Application no: H08-0647-15

Description: Proposed change of use of horticultural building to dwelling (Class C3)

Location: 106 Siltside
Gosberton Risegate
Spalding
Lincolnshire
PE11 4ET
PE11 4ET

ACKNOWLEDGEMENT OF AMENDMENT

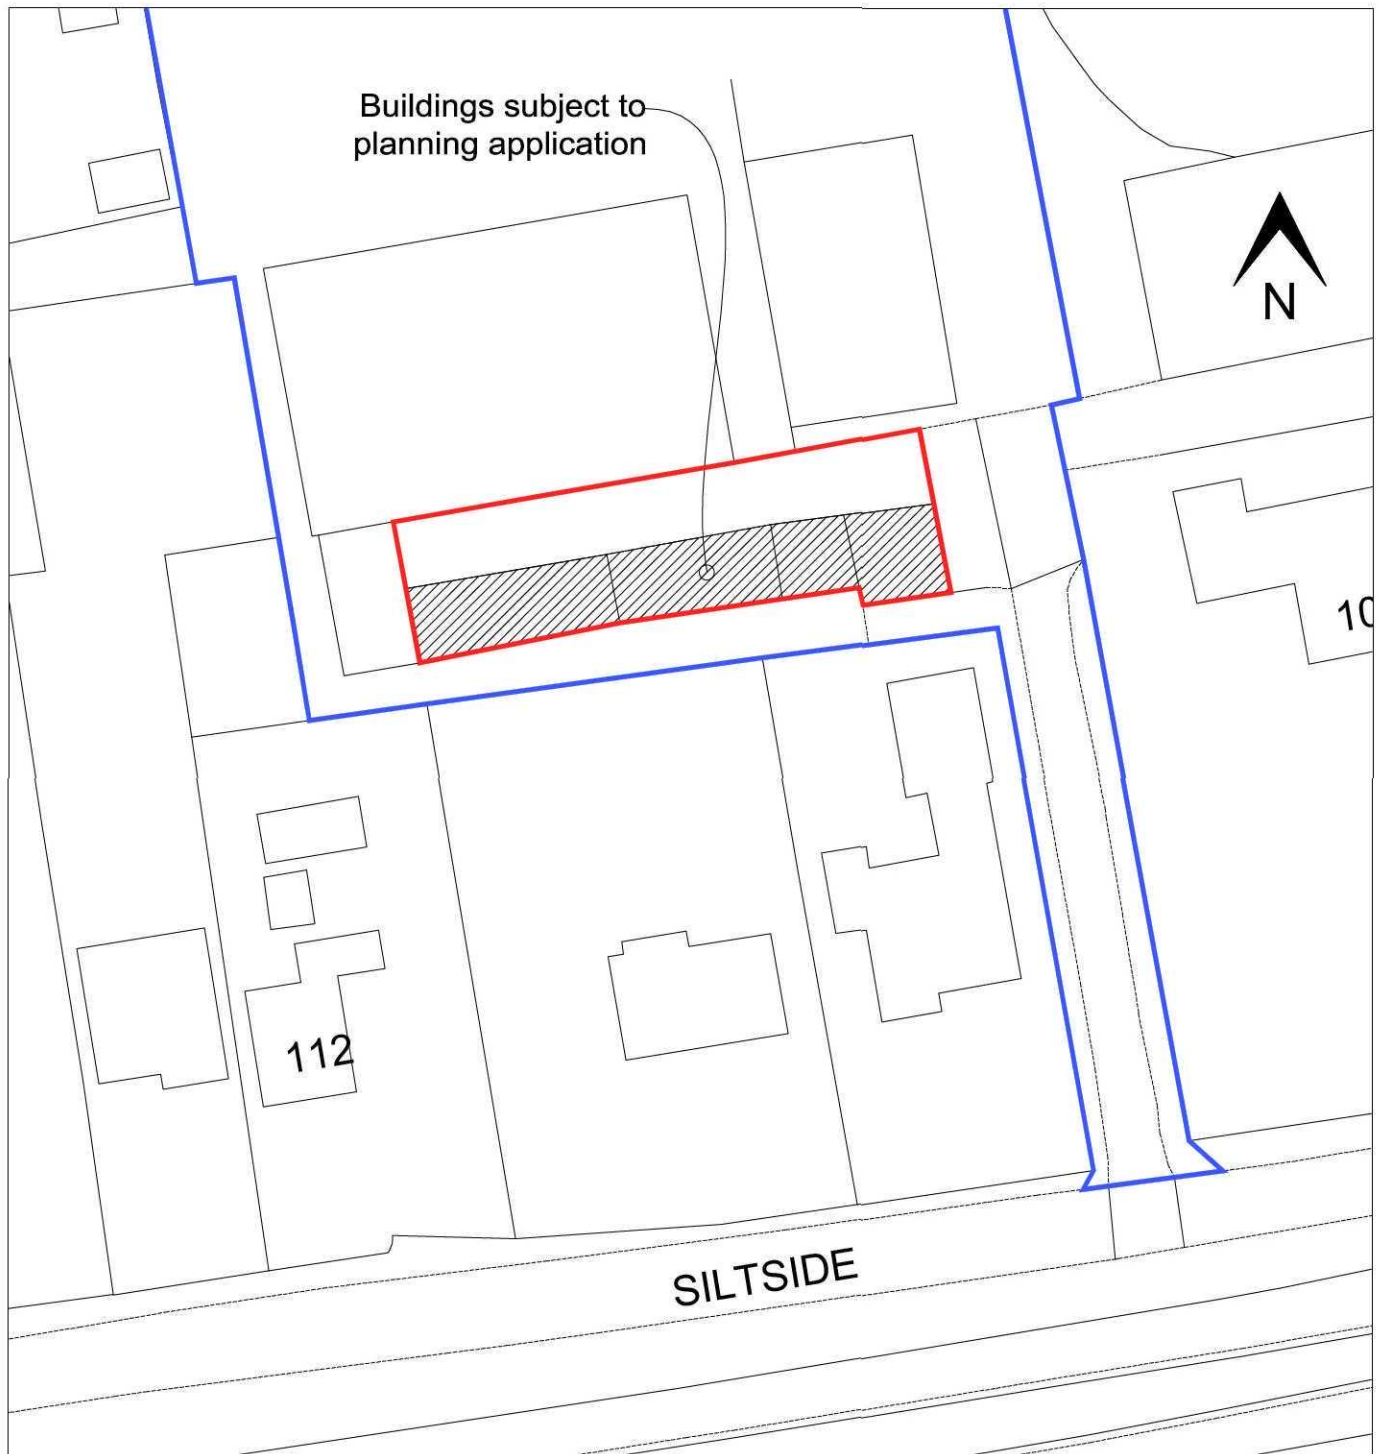
Amendment: Amended red outline, buildings subject of the application
hatched in black (dwg. no. 2-LP01.C & 2-LP02.C)

FULL DESCRIPTION OF DEVELOPMENT OF CURRENT APPLICATION THAT THIS AMENDMENT RELATES TO		Proposed change of use of horticultural building to dwelling (Class C3)	
State details of amendments proposed. (Give a full detailed list of the changes, and also mark these clearly on the accompanying plans. Only the changes listed here will be considered)		Amendment of application site red line boundary: buildings subject of the application hatched in black (Drawing No: 1171-2-LP01 RevC and 1171-2-LP02 RevC)	
State drawing numbers of the current submission		1171-1-LP01A, 1171-1-LP02A	
Has this amendment been requested by the Council? (If so, state Officer dealing with the application)	YES	Tracey Meacham	
Describe any part of the original development which is excluded by virtue of the amendment, and state any alteration to plot numbers		The steel framed and clad building at the west end of the group of buildings has been omitted from the proposal, is excluded from the application and outside the red line.
